From: Daun Johnson
Sent: 13 November 2019 12:10
To: Planning Scanning
Subject: FW: Planning Consultation on: BR/282/19/PL

Engineers Comments Regarding Surface Water Drainage

APPLICATION NO: BR/282/19/PL

Site Address: The Beach Hotel, former Mud Club & 2-4 Waterloo Square Bognor
Regis PO21 1SU

Drawing Status		PLANNING	
Client		B5 Ltd	
Drawing Title		Impermeable Areas Comparison	
Project		Waterloo Square Bognor Regis	
Scale	Date	Drawn By	Checked
1:250	Dec '19	DJL	MJA
Drawing No.		Rev.	
2019-D1832-PL200		-

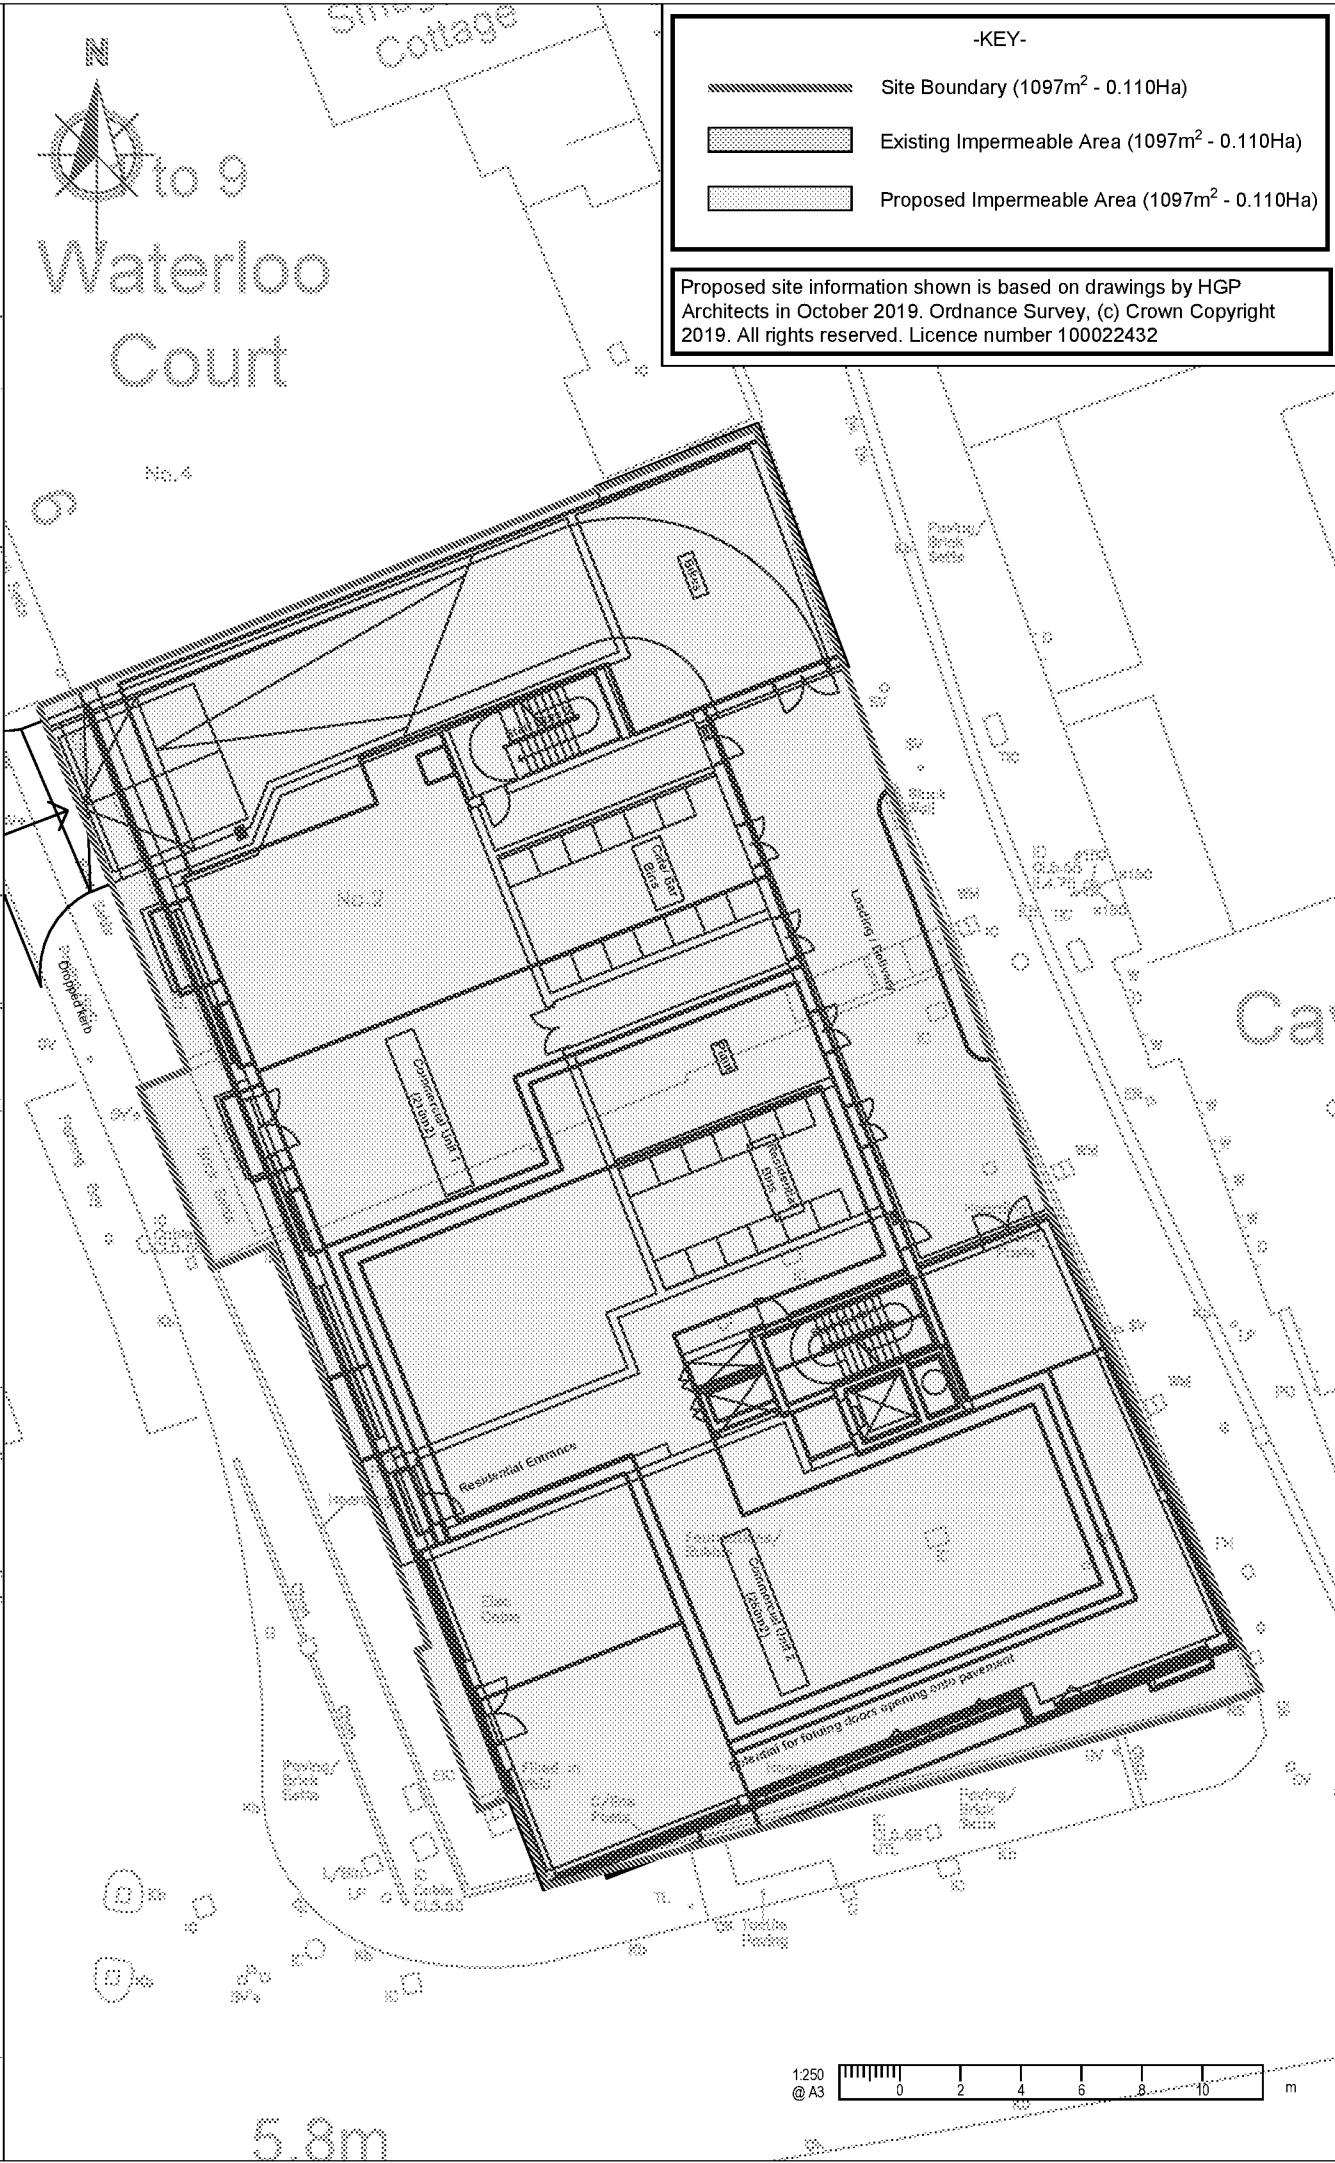
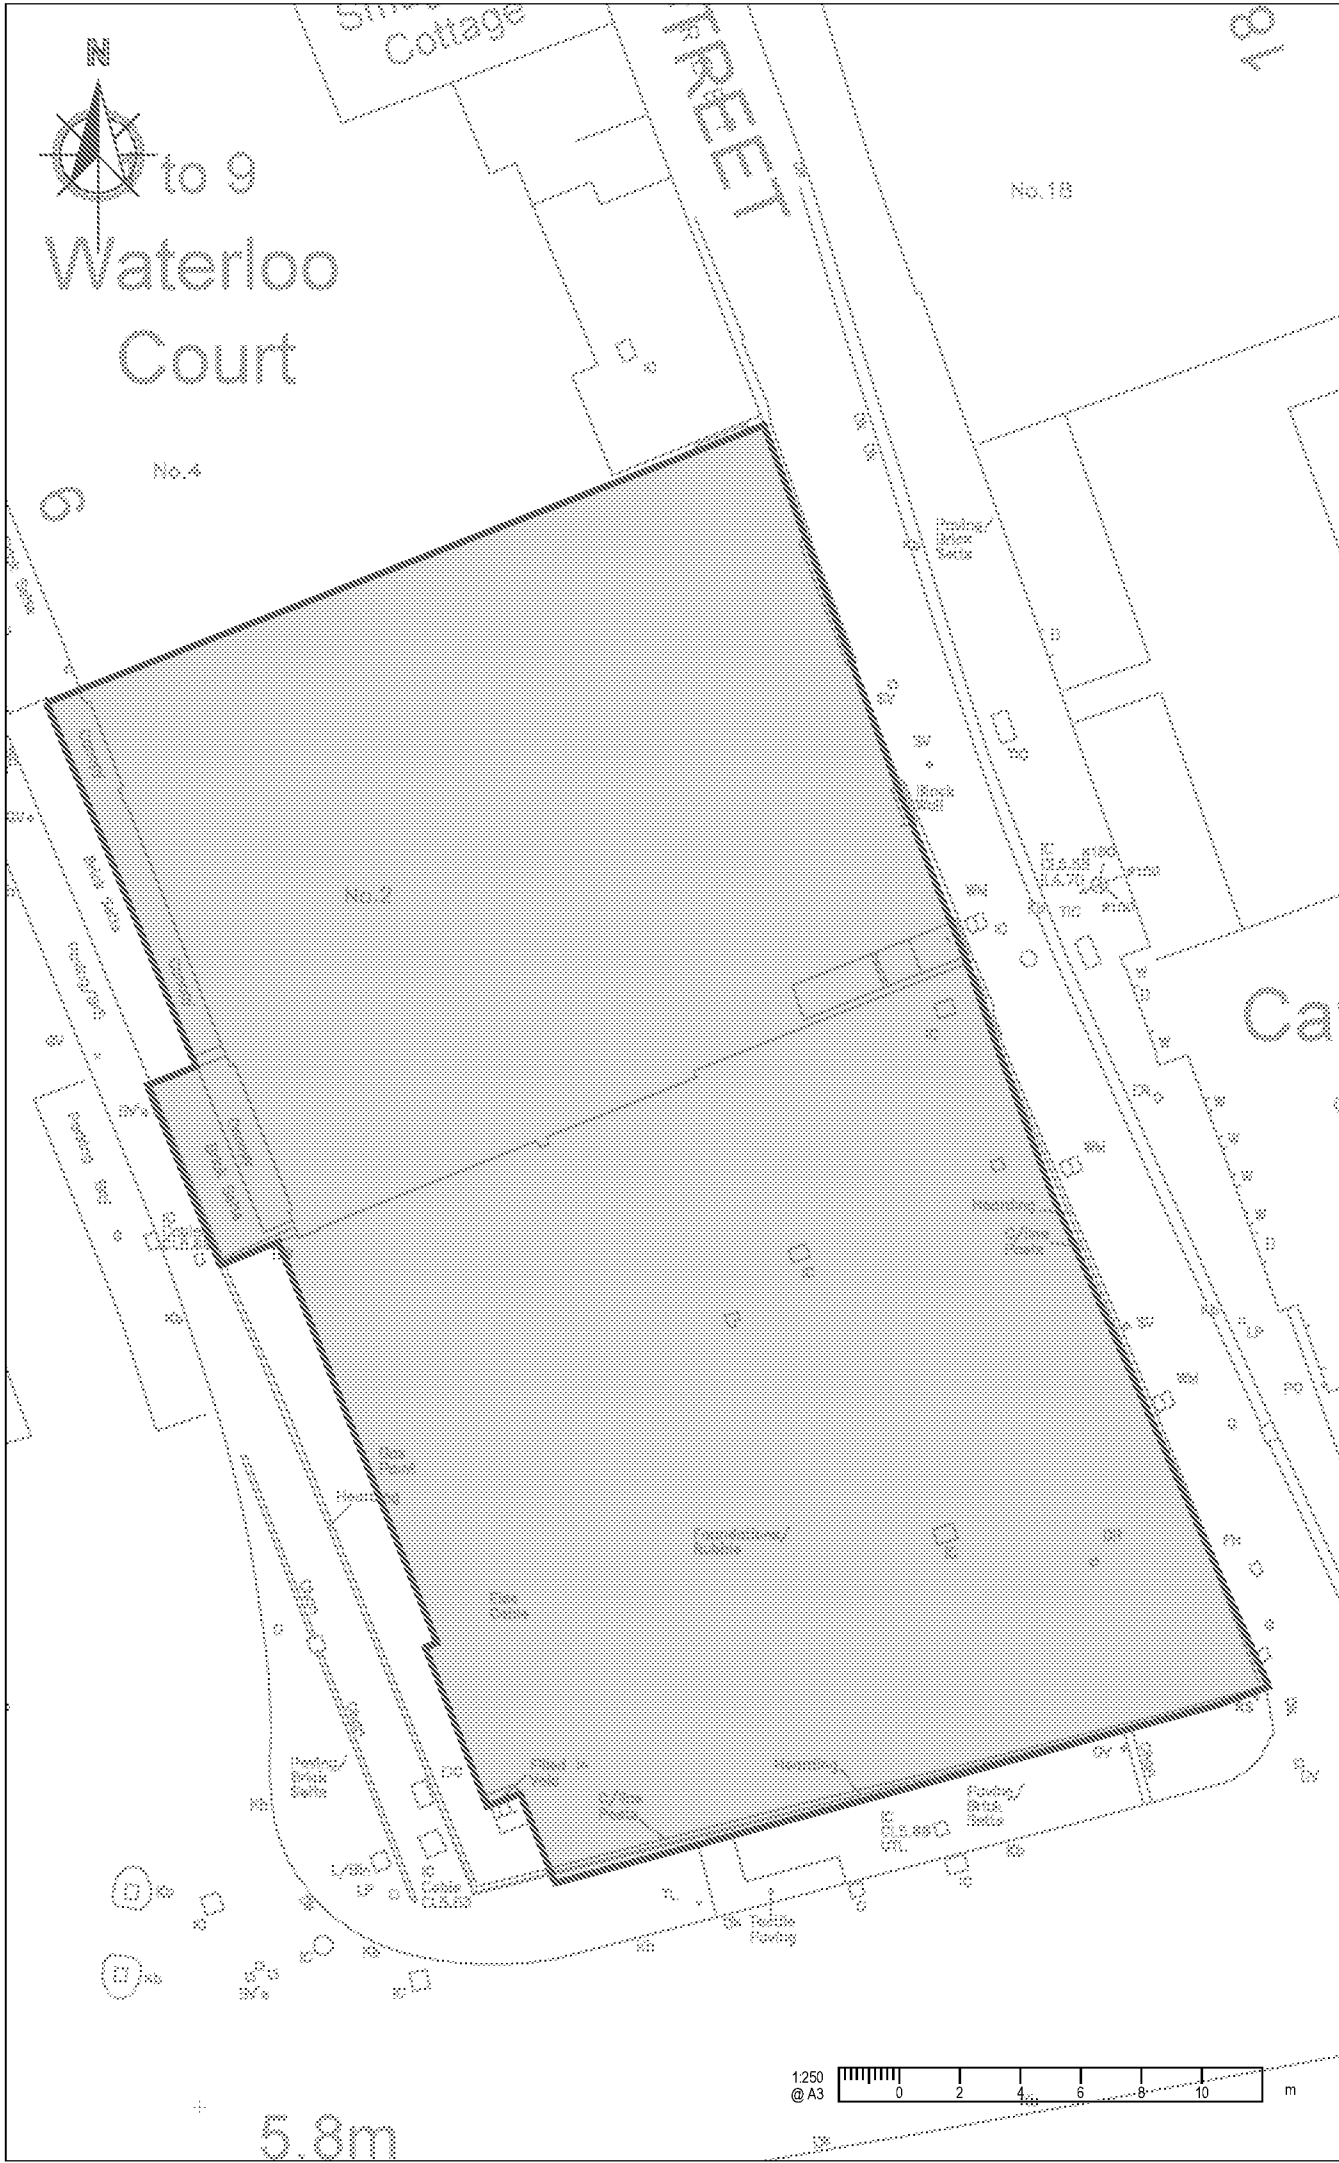
Given that there is a negligible change in impermeable area we have no conditions to request. However, as the site is likely to drain to the public surface water sewer please consult Southern Water. The applicant proposes to attenuate surface water on site, however it is difficult to discern where the storage will be located, given the intense proposed development of the site (including basement), however this will be a matter for Southern Water.
